Town & Country Planning Act 1990 (as amended)
Town & country Planning (Development Management Procedure) (England) Order 2015
Application for Planning Permission for Works or Extension to a Dwelling

Development Two storey rear extension (resubmission following AW/271/17/PL). This application also lies within the parish of Pagham.

Location 36 Apple Grove Aldwick

North Elevation Proposed 1:100

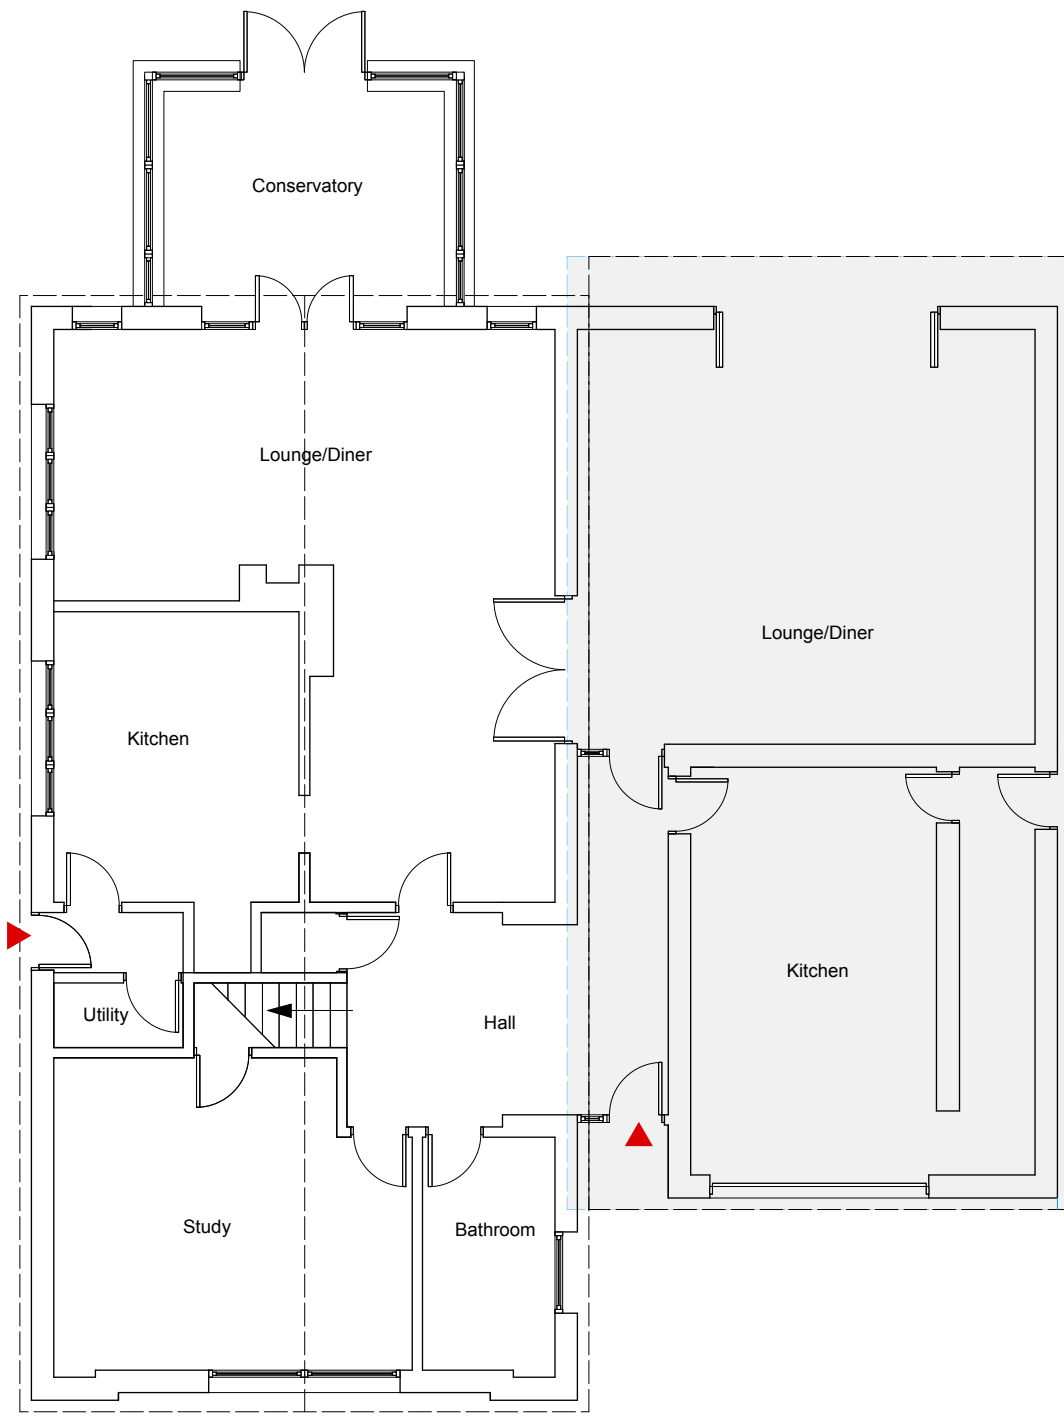
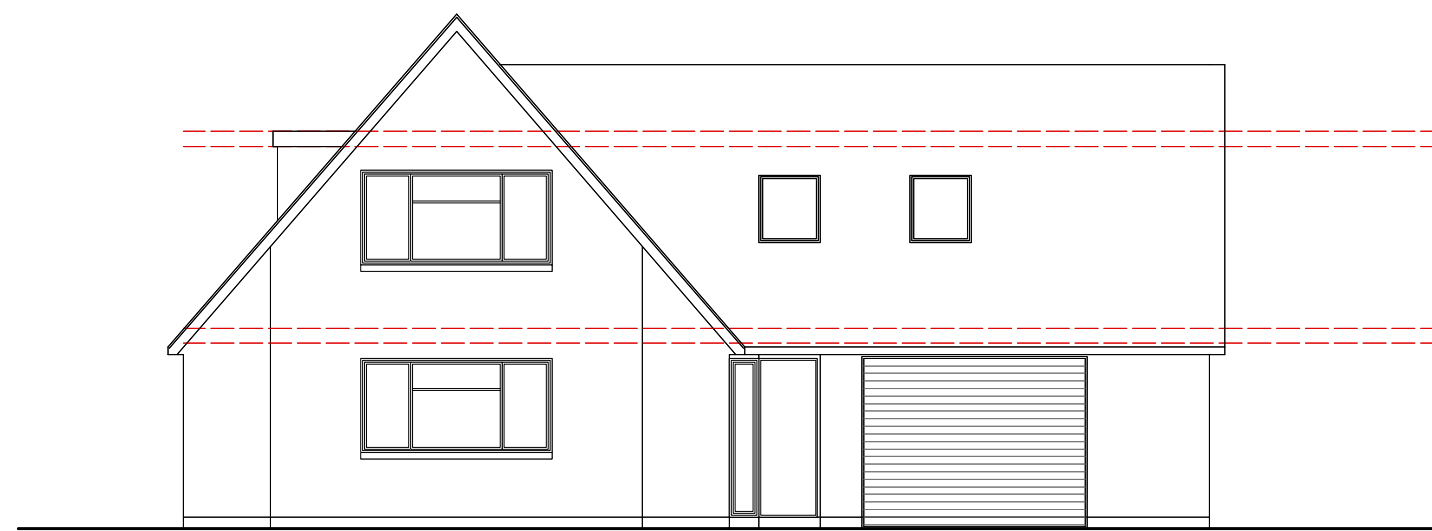
The proposed ground floor plan and north elevation do not accord. Please amend accordingly.

West Elevation Proposed 1:100

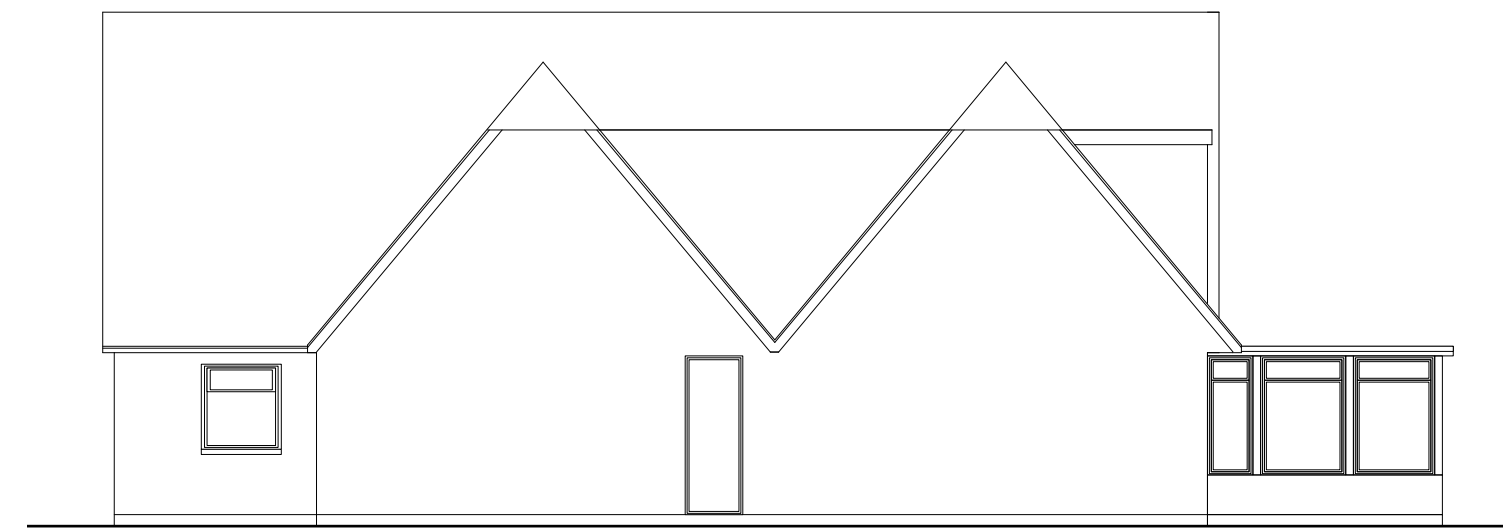
The proposed ground floor plan and west elevation do not accord. Please amend accordingly.
